Bracknell Forest Borough Council  
Market Street  
Bracknell RG12 1JD

28 February 2024

**47 Fernbank Road, Ascot SL5 8HY  
BRE Daylight and Sunlight**

DRAWING No.
47/FR/PL/120

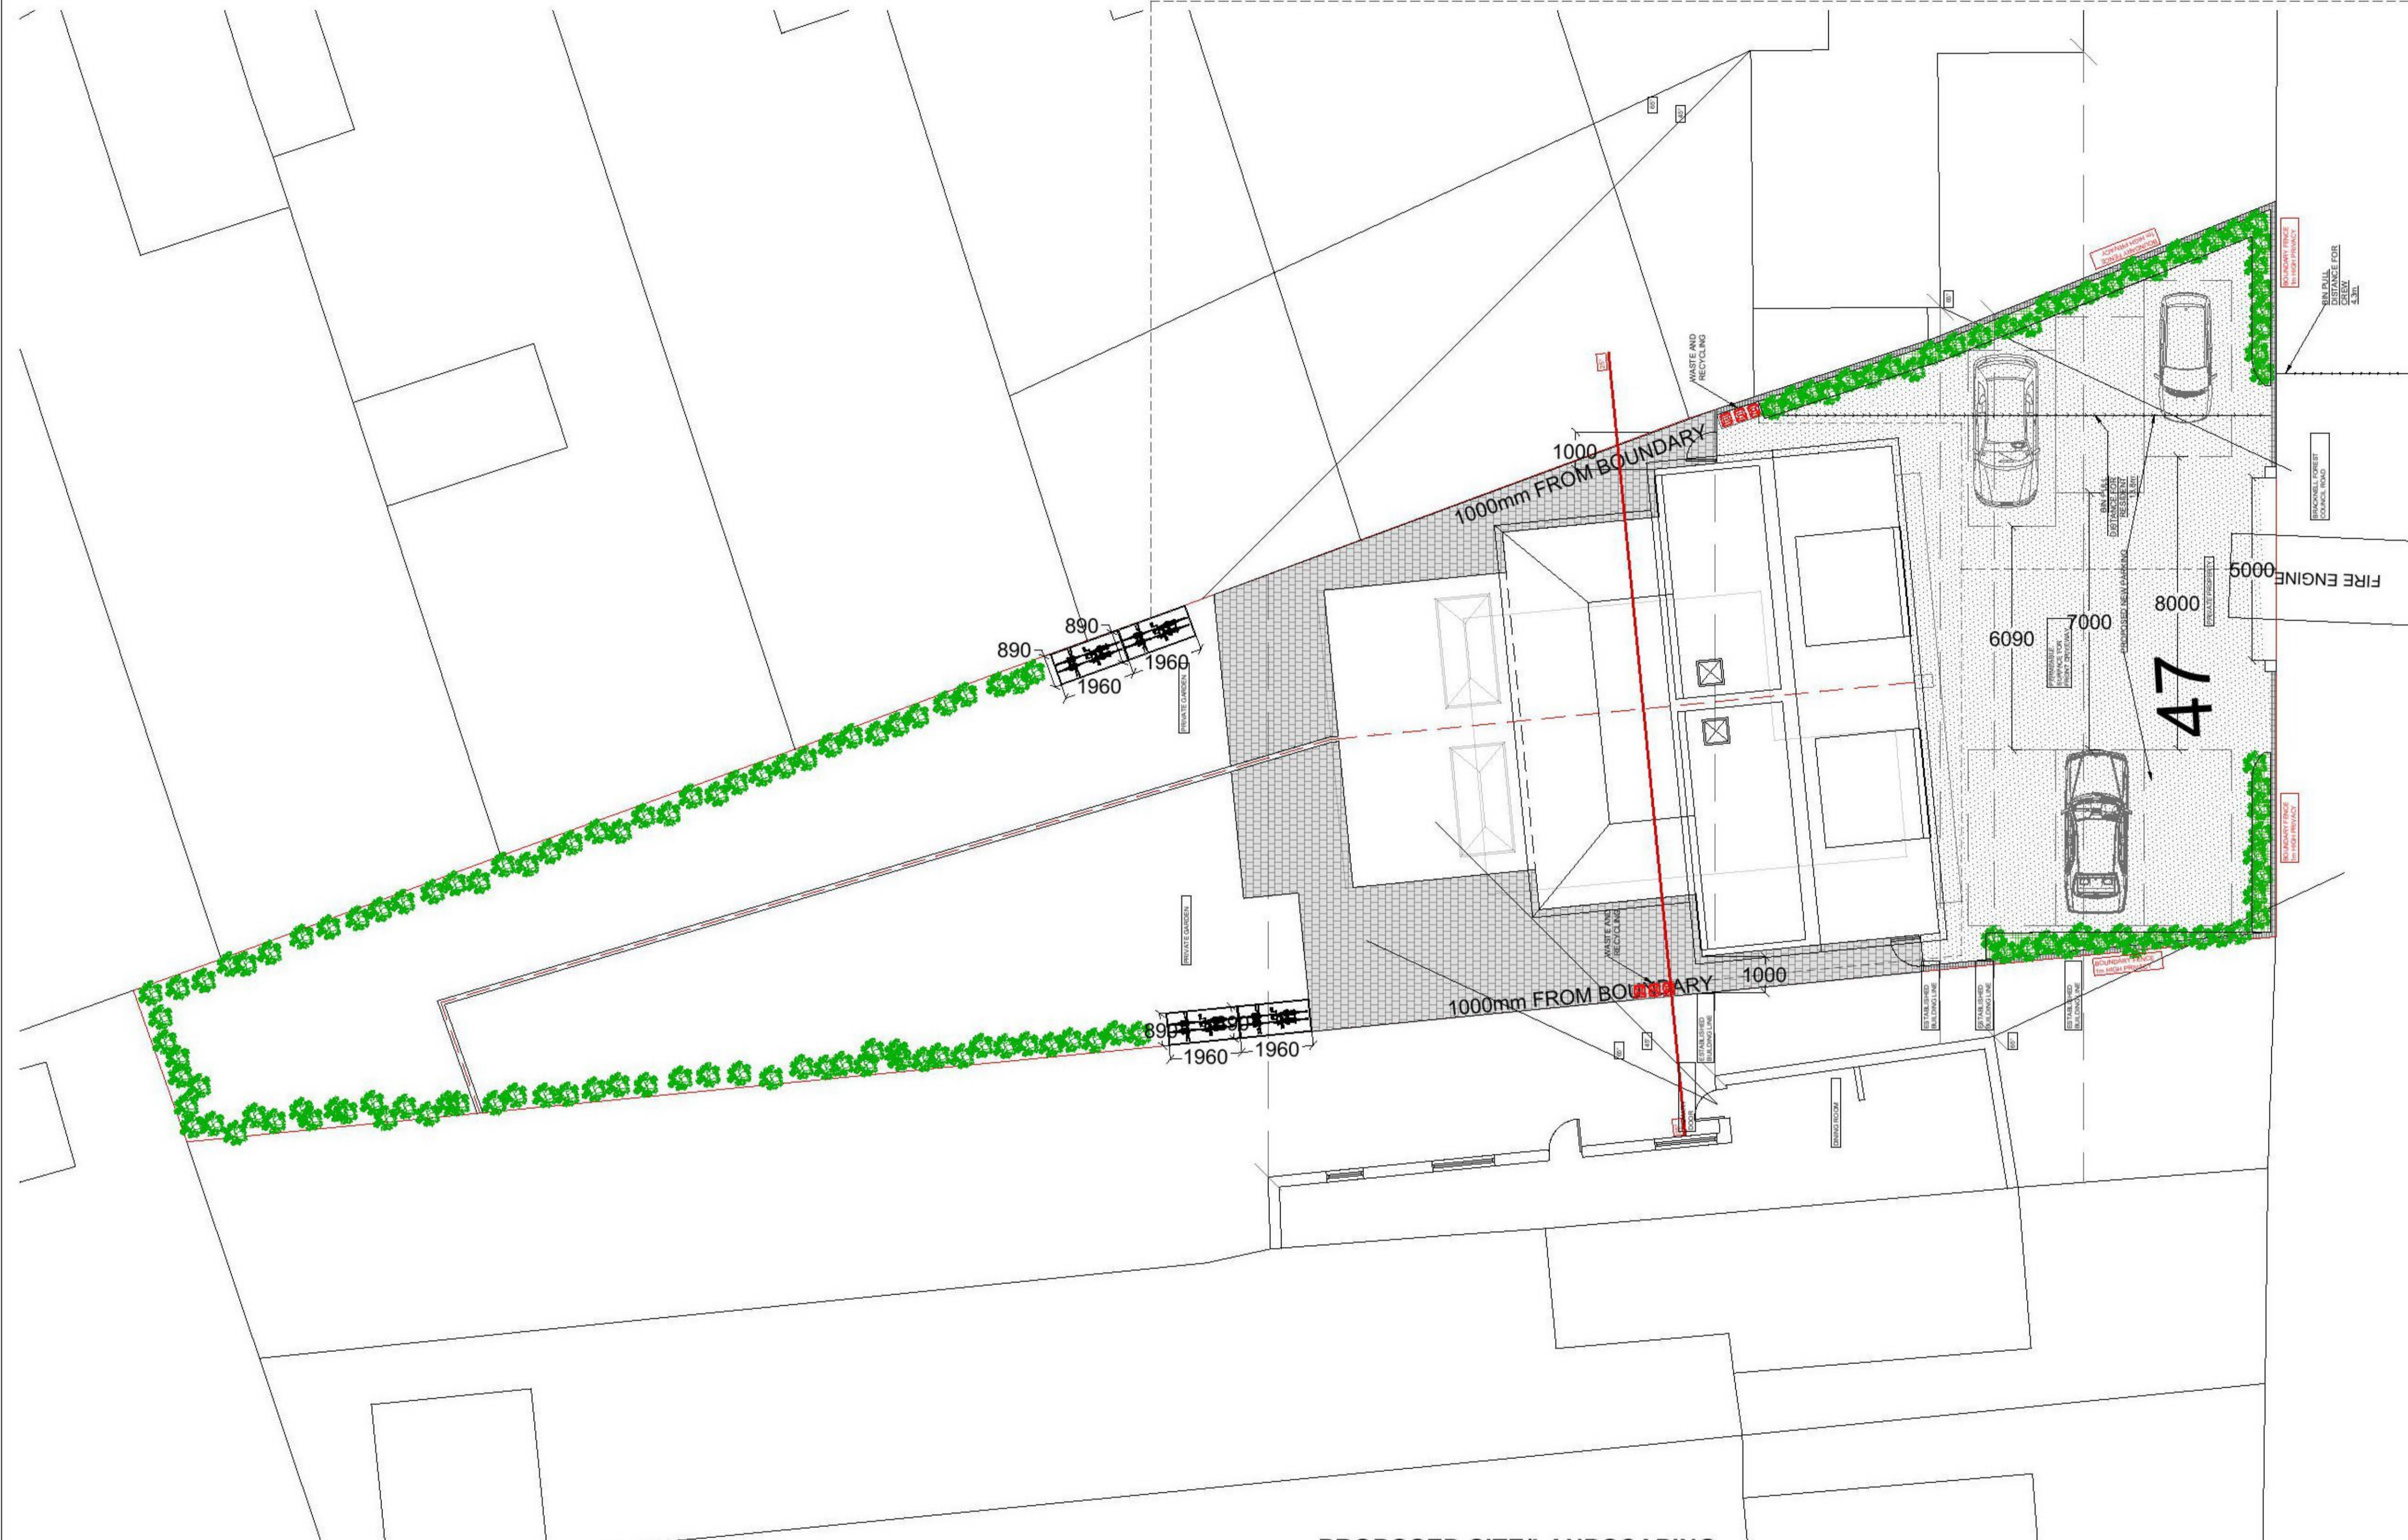
Drawing 120 (enclosed) shows that the proposal satisfies the 45 degree test when applied to the rear elevation window.
